Application for Removal or Variation of a Condition following Grant of Planning Permission or Listed Building Consent

Number	4
Suffix	
Property Name	
Address Line 1	Harvil Road
Address Line 2	
Address Line 3	Hillingdon
Town/city	Ickenham
Postcode	UB10 8AJ

Erection of a two storey, 6-bed, detached dwelling house with habitable roof space and additional vehicular crossover, involving demolition of existing dwelling house.

76195/APP/2023/2332

C354-12 Proposed Ground Floor Plan (Rev E)

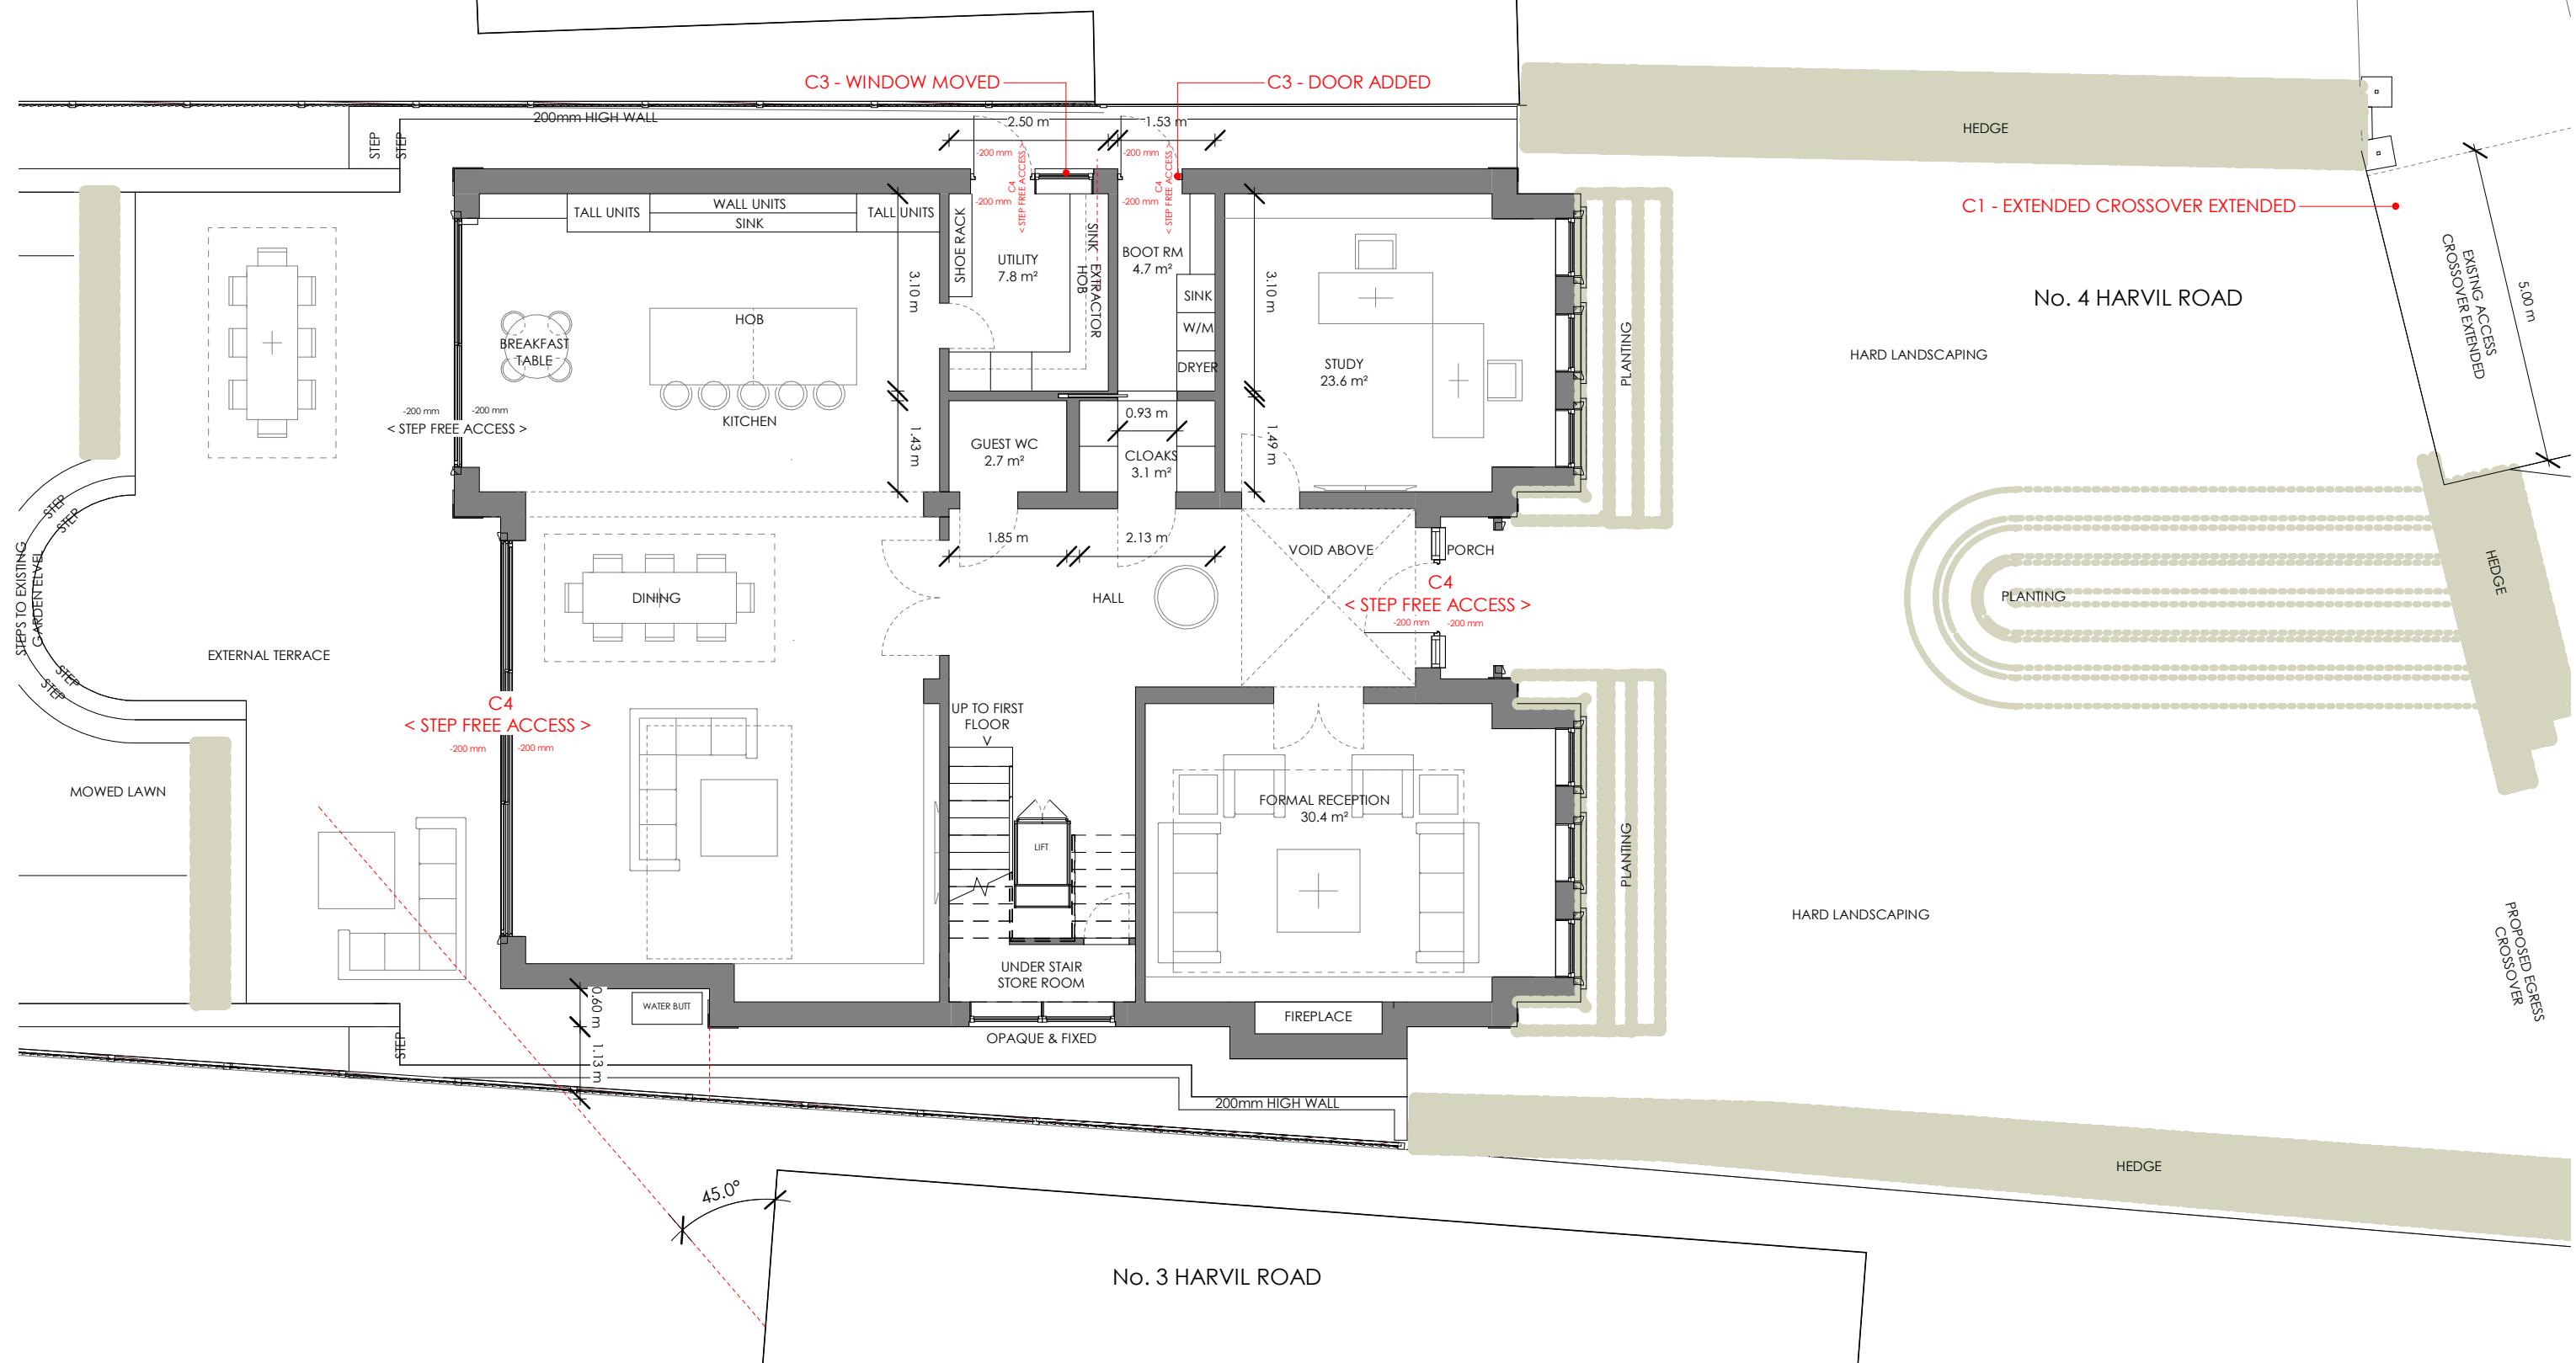
C354-10 Proposed Roof Plan (Rev C) changed to C354-10 Proposed Roof Plan (Rev E)
C354-12 Proposed Ground Floor Plan (Rev D) changed to C354-12 Ground Floor Plan (Rev E)
C354-13 Proposed First & Second Floor Plans (Rev C) changed to C354-13 Proposed First & Second Floor Plans (Rev E)
C354-15 Proposed Side Elevations (Rev C) changed to C354-15 Proposed Side Elevations (Rev E)
C354-16 Proposed Sections (Rev C) changed to C354-16 Proposed Sections (Rev E)

C354-13 Proposed First and Second Floor Plans (Rev E)

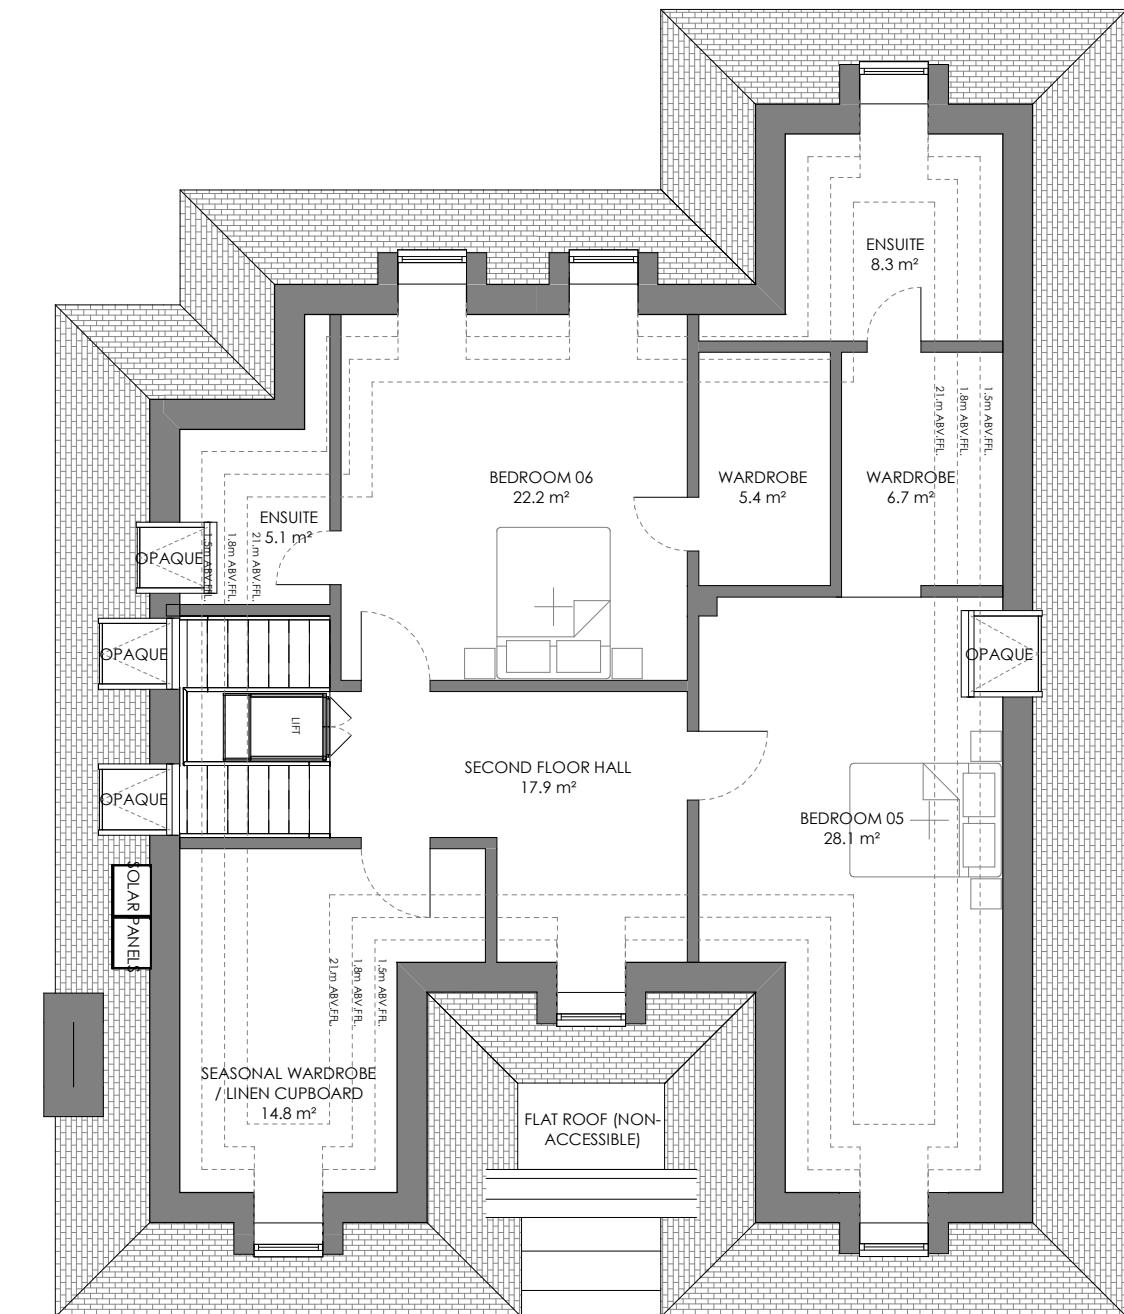
Condition 02 - Door added to side elevation with window repositioned and window added to first floor side elevation.
Condition 03 - Construction Management Plan submitted to remove condition.
Condition 08 - Additional information added to Proposed Block Plan and within Construction Management Plan to remove condition.
Condition 10 - Additional information added to Proposed Ground Floor Plan showing step free access to remove condition.
Condition 14 - Remove condition as tests of reasonableness and necessity are not met
